CITY OF ALBUQUERQUE

July 28, 2025

RE: 10120 Coors Blvd NW
Grading and Drainage Plans
Engineer's Stamp Date: 7/8/25
Hydrology File: B14D013
Case # HYDR-2025-00252

Precipitation Zone: 1

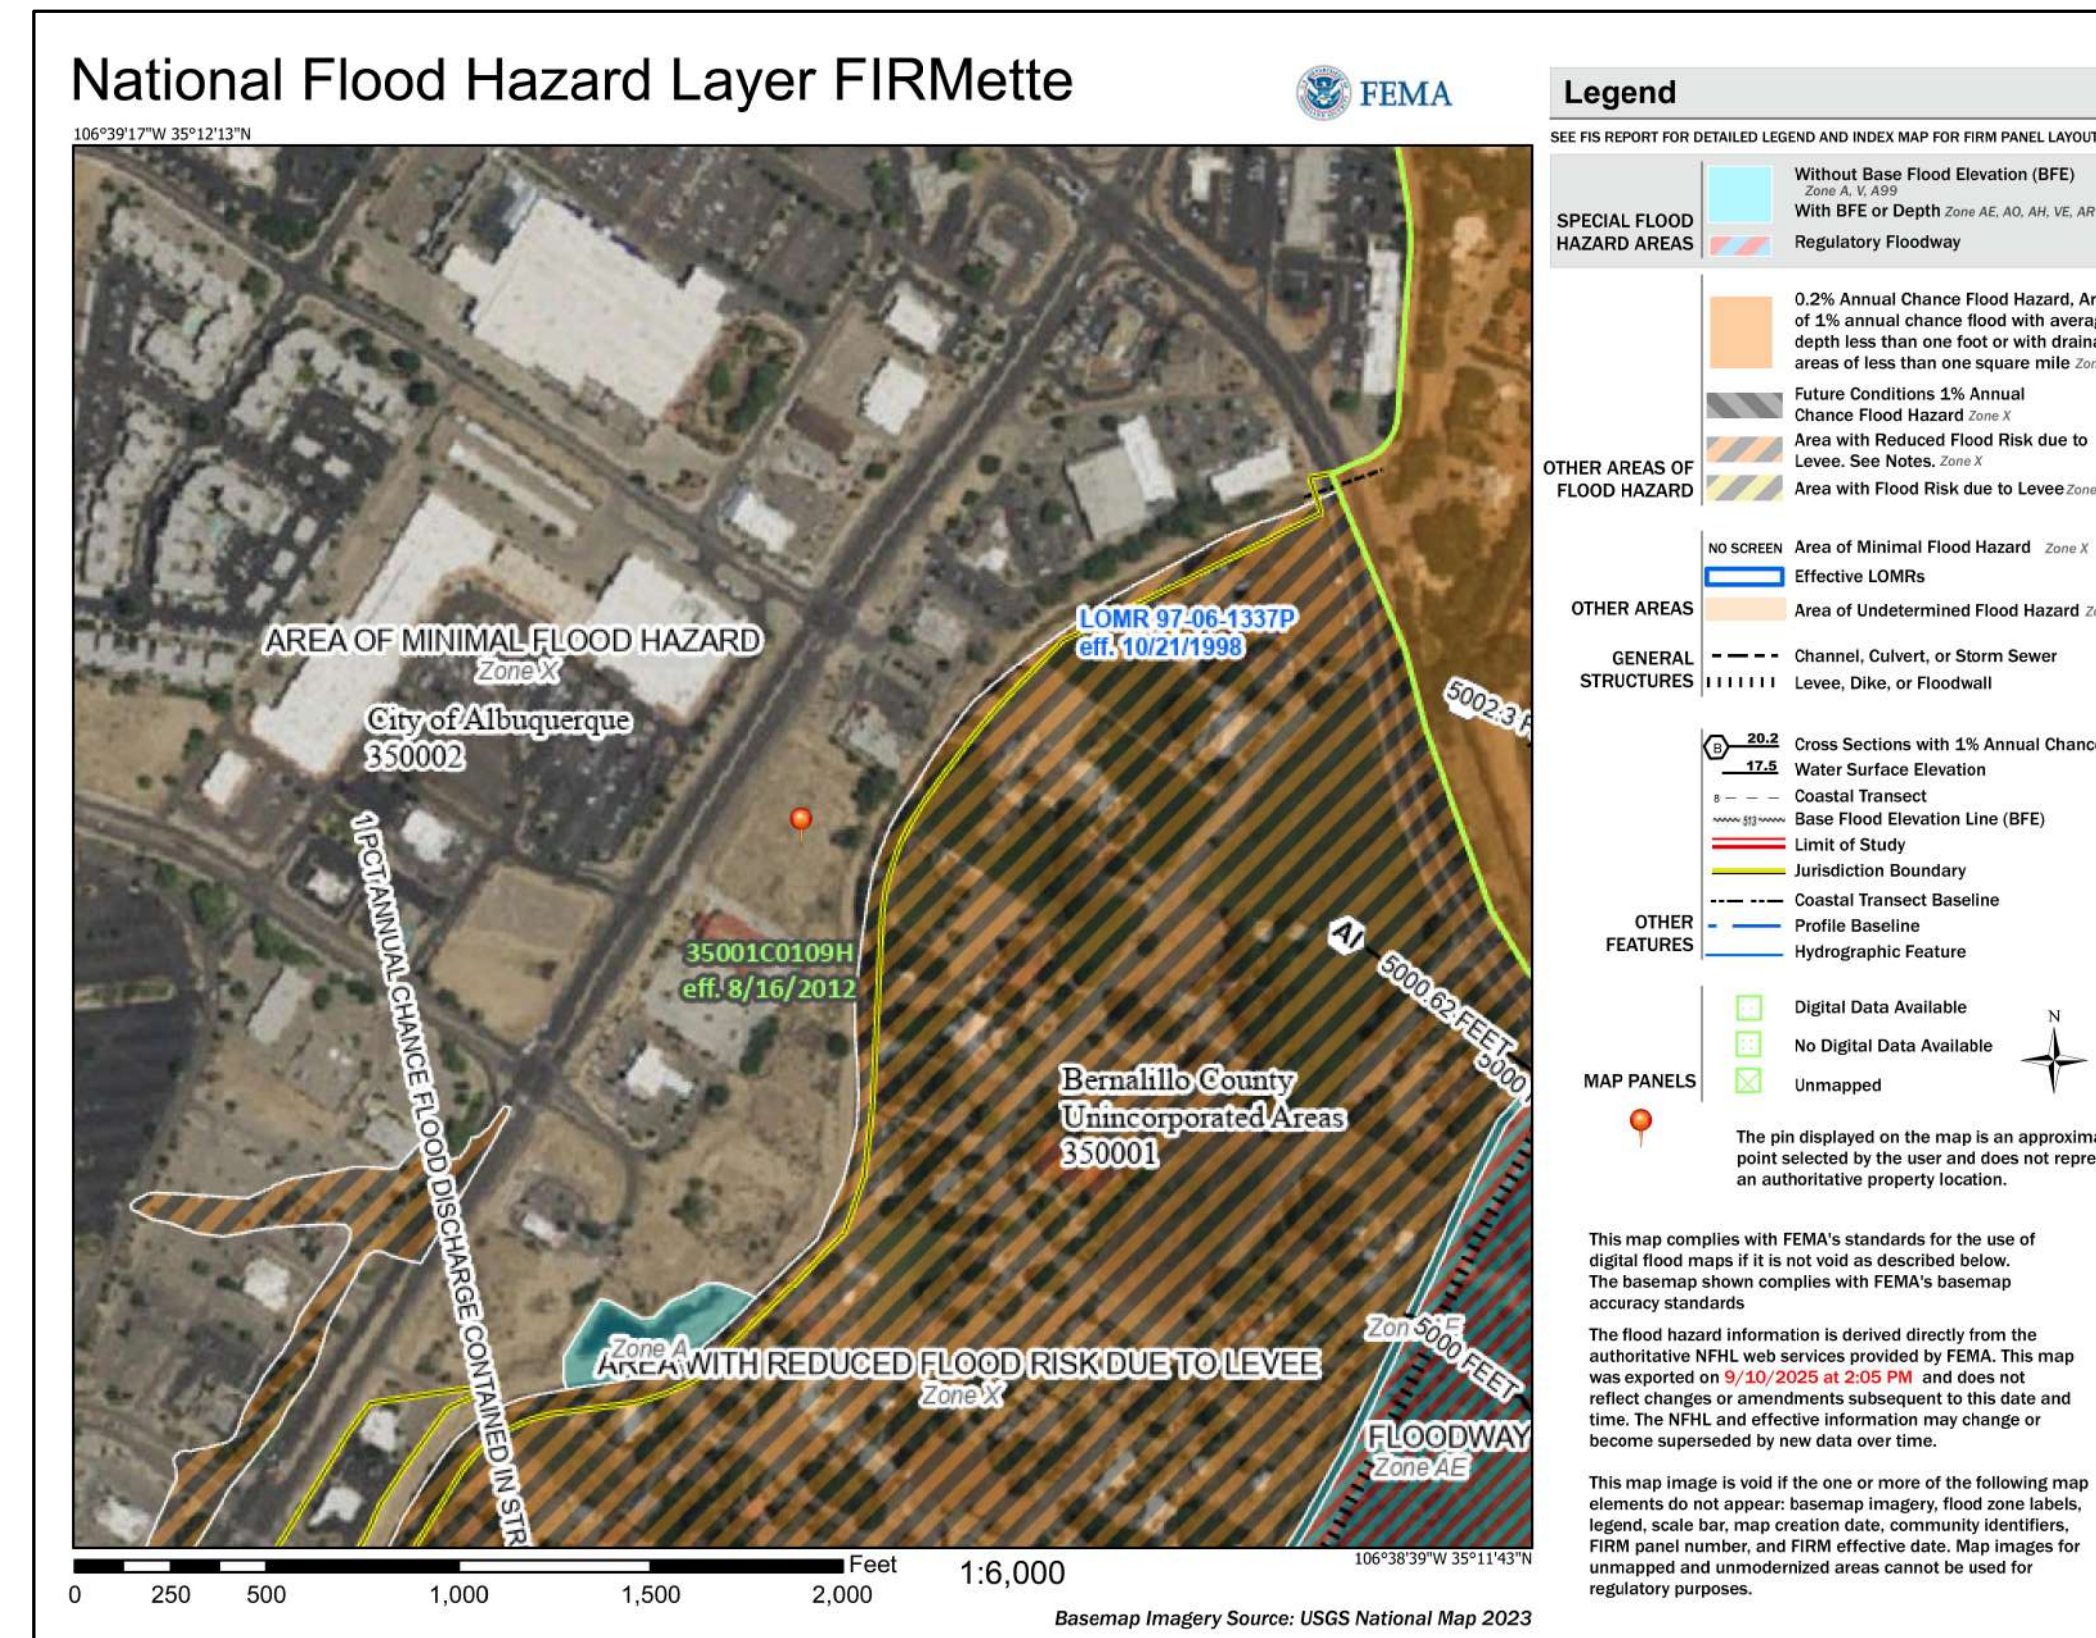
1. Please provide the FIRM Map for this site.
2. Is the 48" storm drain line to be extended through the Work Order process?
3. Show profile of 48" and the other storm drain lines.
4. Identify ownership of the storm drain lines.
5. Show the property lines for this lot.
6. Show the Finished Pad elevations in addition to the Finished Floor elevations.
7. Label the 200CF Basin C Pond.
8. Since this project is adjacent to, or drains into an Albuquerque Metropolitan Arroyo and Flood Control Authority (AMAFCA) facility, approval by AMAFCA will be need prior to Hydrology approval. Please contact Jared Romero P.E, CFM (jromero@amafca.org or 505-884-2215).
